DECISION DELEGATED TO HEAD OF PLANNING

Application No:	H09-0980-21	Applicant:	Seagate Homes (UK) Ltd.
Proposal:	Residential development comprising 5 detached dwellings off a private drive		
Location:	Land North Of Tudor Lodge Fen Road Holbeach		
Terminal Date:	7th May 2022

CASE OFFICER ASSESSMENT

RESIDENTIAL DEVELOPMENT, TUDOR LODGE,
FEN ROAD, HOLBEACH

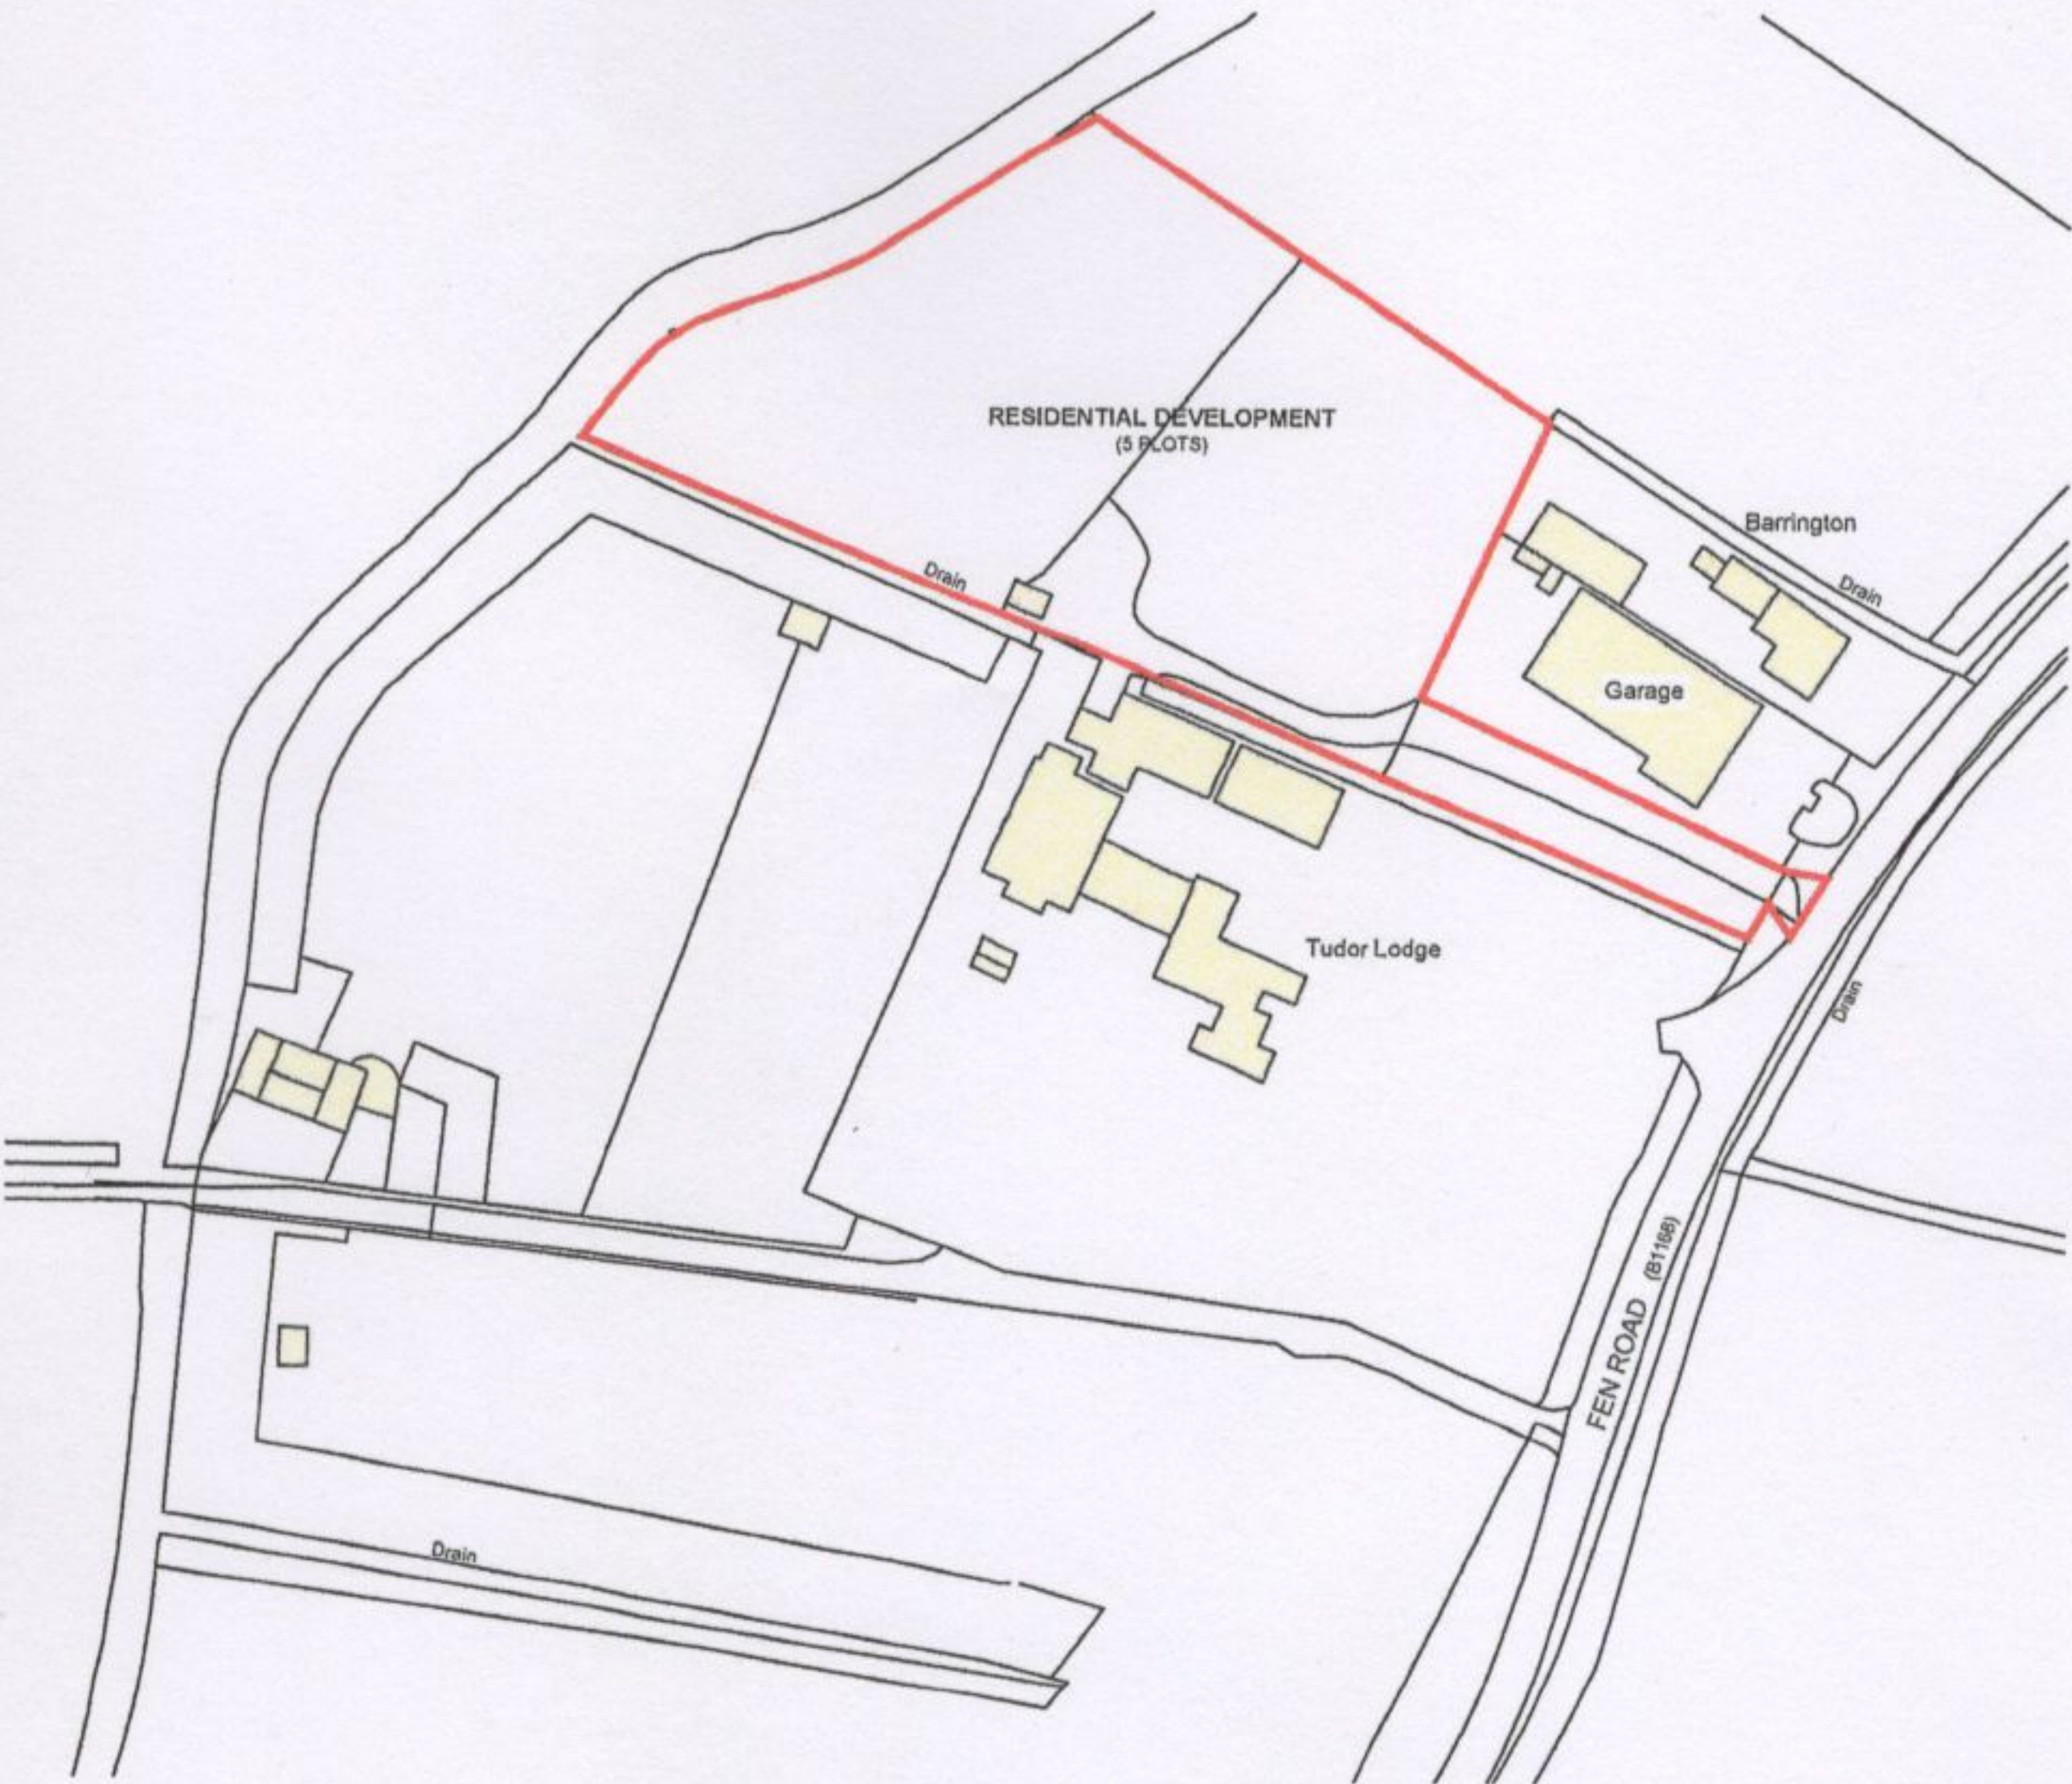
The proposed site plan within the FRA (drawing no. TL-SH-PSP-AR-01 Sep 2021) disregards the presence of the riparian watercourse along the southern site boundary. This is misleading and the plan needs to be redrawn showing the private watercourse which is identifiable on the Highways map. Any proposed alteration to this watercourse, such as culverting or infilling, will require the Board's consent under Section 23 of the Land Drainage Act 1991 and byelaw 4. This watercourse serves to convey water away from Fen Road into Holbeach Old River.

Regarding the footpath construction, both Highway and Lead Local Flood Authority and the Board supports the principle for providing safe and suitable pedestrian access along Fen Road. In drawing TL-SH-PCF-AR-02 sections D-D and E-E illustrate proposed alterations to the profile of the watercourse which will require the Board's consent. The profile section at the bottom of the drawing should read F-F and (not E-E). This relates to the existing field access crossing where there is a wooden field gate presently. The Board is uncertain as to whether this crossing is piped, or not. The works proposed at F-F appear to be surficial, requiring a minor regrading of ground levels only. Any tie-in to the Ashwood Homes Development Entrance to the north which might affect the watercourse profile will also need consent from the Board under the same application. Additionally, profile sections A-A, B-B and C-C are to crossfall toward the existing carriageway to disperse surface water away from existing properties as not to create surface water flooding. The kerbing specified should permit drainage from the road surface into this watercourse to reduce ponding on the highway surface. The Board also have concerns however, about the watercourse having sufficient capacity to accommodate excess surface water in the absence of a confirmed connection with Holbeach Old River.

The Fire Authority objects to this planning application on the grounds of inadequate access and turning for a fire appliance. The proposed site layout plan indicates an existing turning facility at the end of the existing access roadway. The turning facility will need some relatively minor alterations to

provide turning provisions for a fire appliance. This is the opinion of the Fire Authority to ensure the long-term fire safety of the occupants and to remove this objection the following measures are required:-

Access to buildings for fire appliances and fire fighters are specified in the Building Regulations 2010 Part B5. The vehicle access road will be a minimum width between kerbs for pumps of 3.7m. The minimum turning circle between kerbs for pumps should be 16.8m and between walls 19.2m. A turning facility is required because the dead-end access route is more than 20m long. This can be a hammerhead or turning circle.

Lincolnshire Fire and Rescue also requires that the access road surface construction is of minimum carrying capacity for pumping appliances of 18 tonnes and not 12.5 tonnes as detailed in the Building Regulations 2010 part B5.
